**Consultation Response from KC,
Trees****2023/90772 Land at, Penistone Road, Fenay Bridge, Huddersfield, HD8 0AW****Discharge conditions 3 (CEMP), 7 (waste collection), 14 (soft landscape), 17 (boundary treatment), 25 (tree/shrub planting) on previous permission 2020/90725 for erection of 68 dwellings with associated access, parking and open space (revised plans)****Date Responded: 17/04/23****Responding Officer: Nick Goddard****Responding Ref: 03a/03**

Drawing No: 22/491/FST/EXT/001 Revision:
Job No: 22-491 Date: 19.12.22

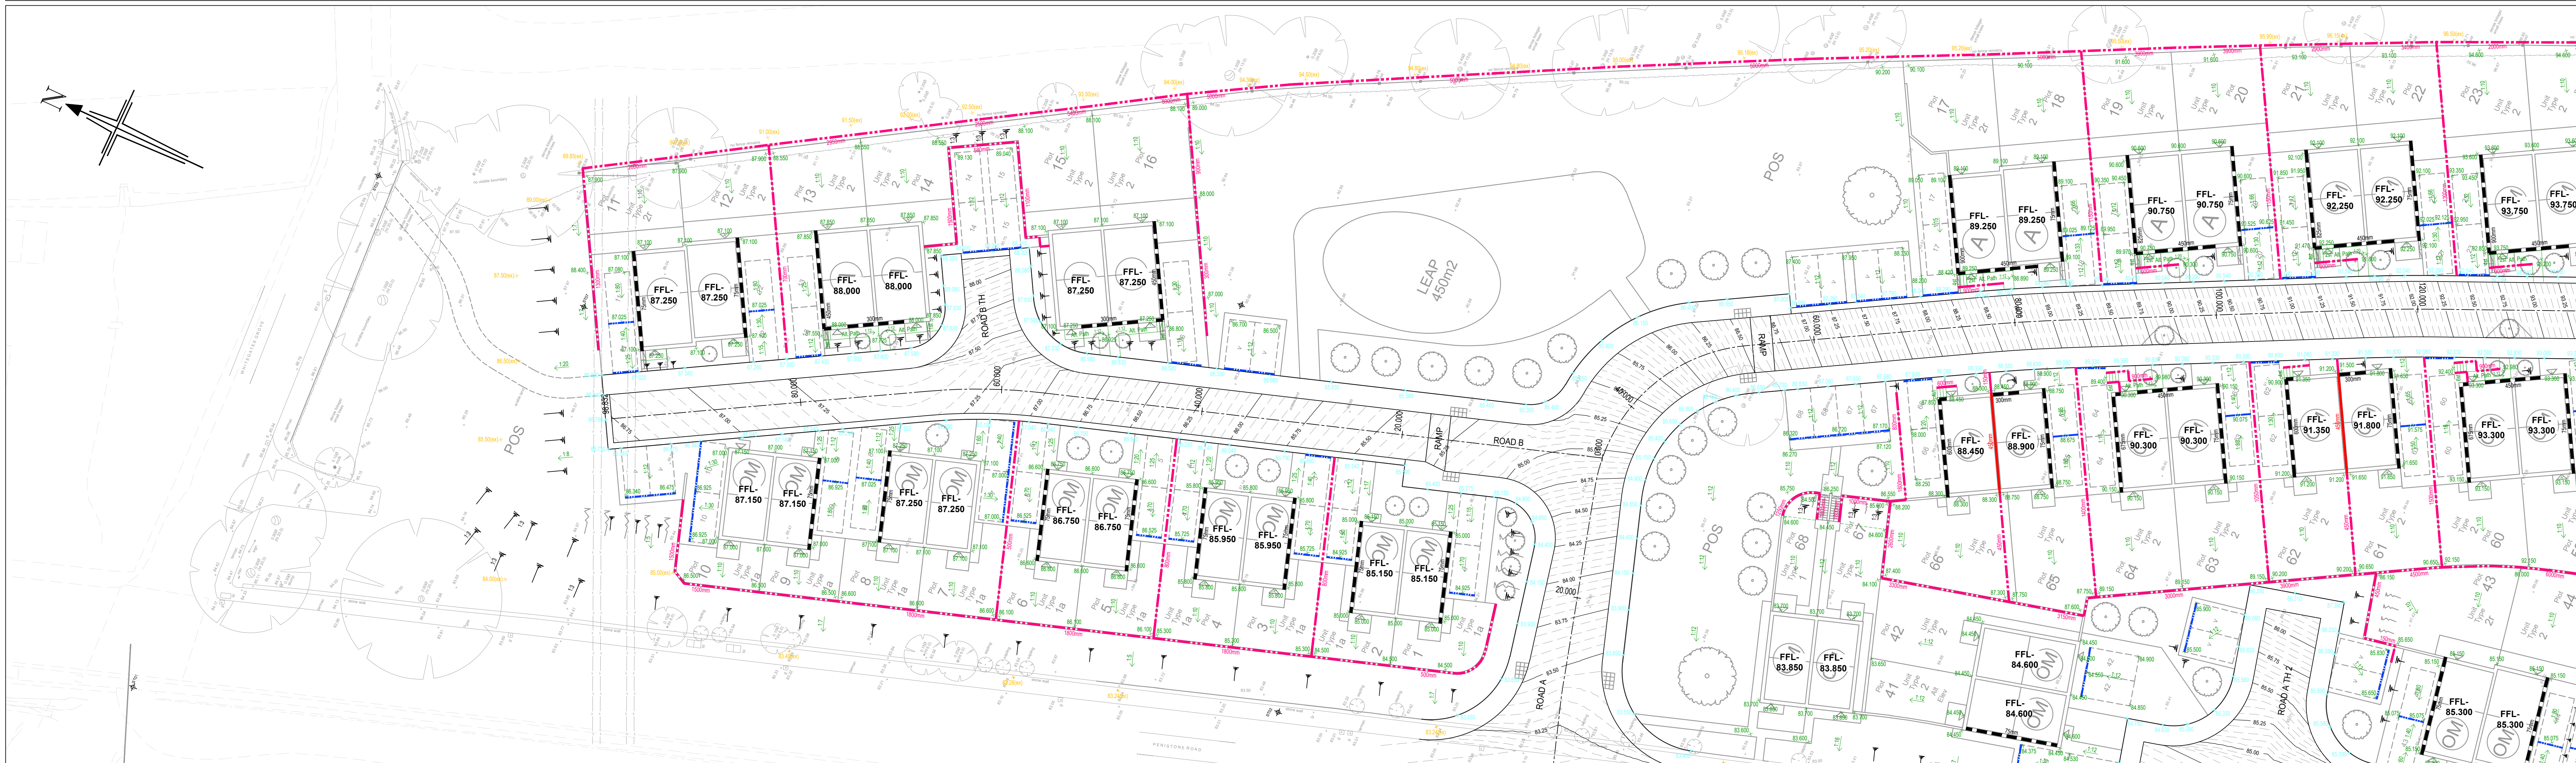
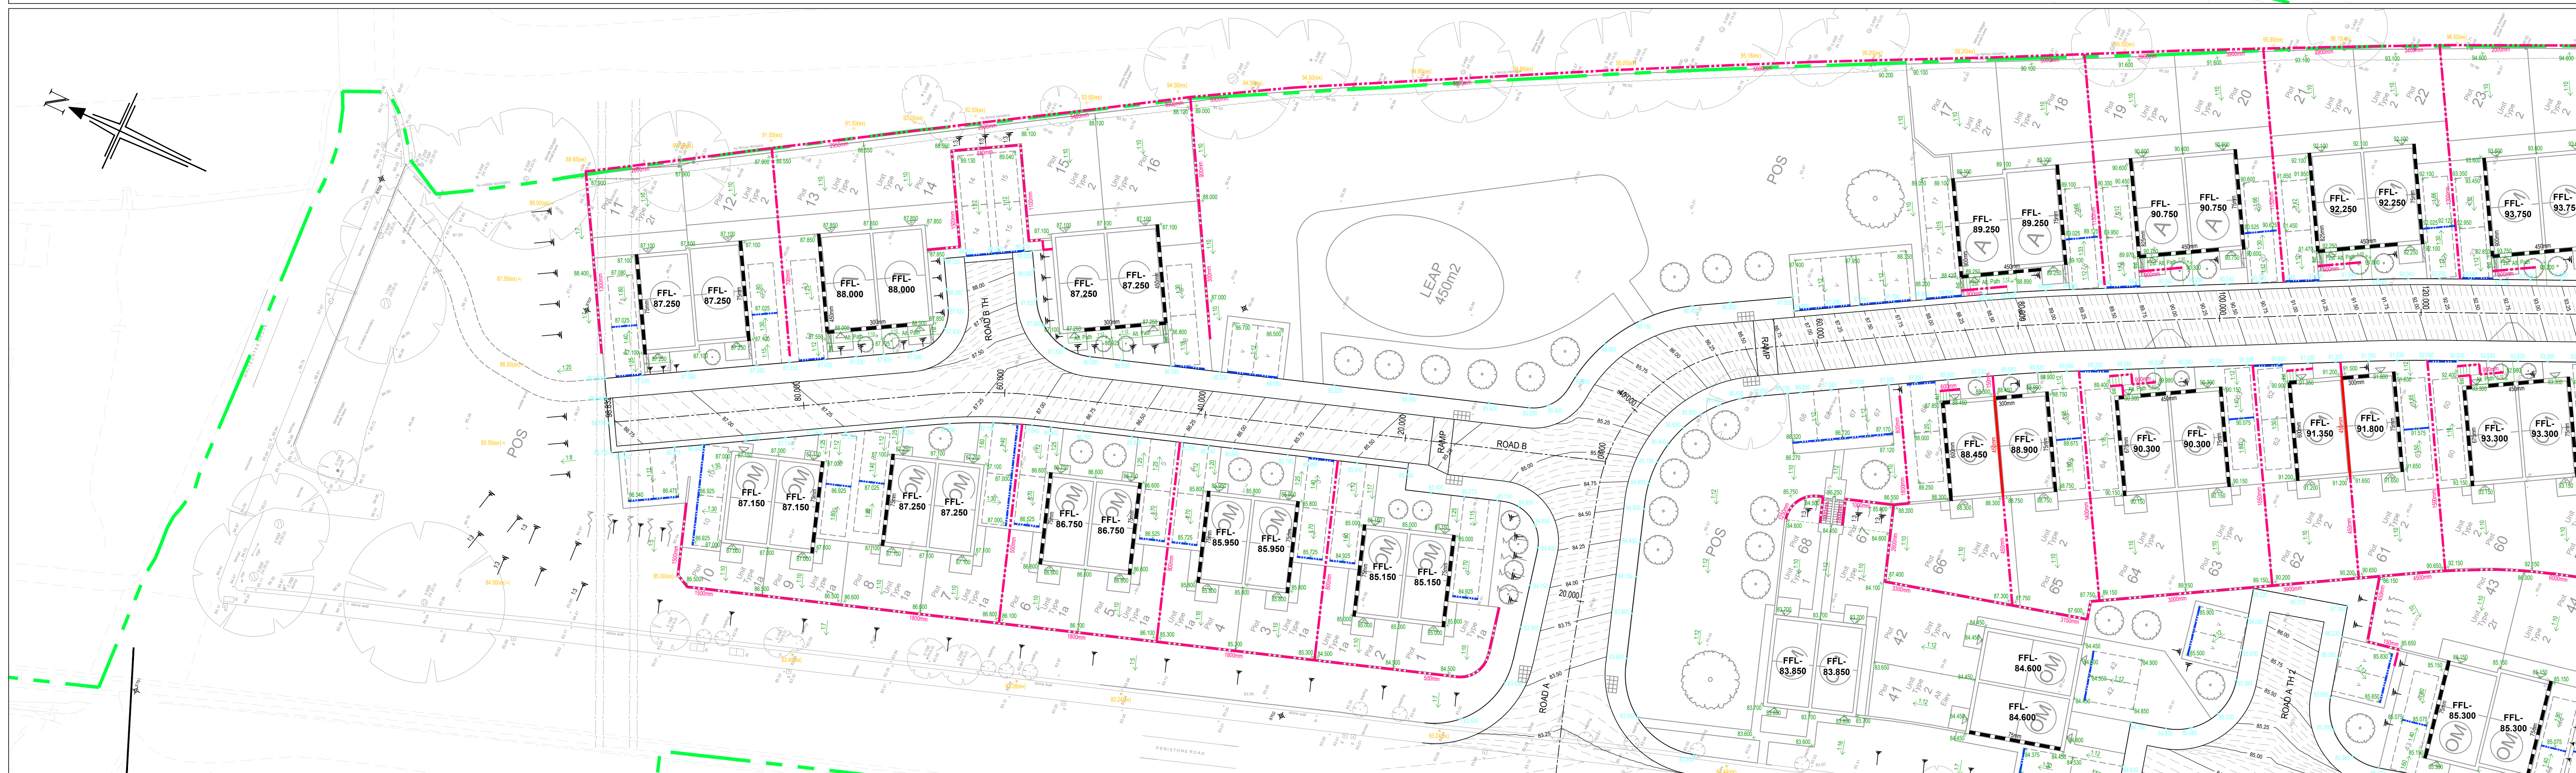
With regards to condition 17, boundary treatments, I have concerns about the inclusion of a retaining wall at the rear of Plot 36, 37 & 38. The plans show this as retaining wall to engineer's details however at the rear of these plots is a significant Oak tree, and the ground level around the tree should not be altered by the installation of a retaining wall. This issue was raised in my comments prior to the approval of the scheme.

No details of the retaining height have been provided and I am concerned the retaining wall proposed would result in significant root loss for this tree. I would like to see details or have an explanation as to why a retaining structure must be in place at the above plots. If it is necessary as shown, then details of its construction need to be provided along with how the roots of the tree will be protected.
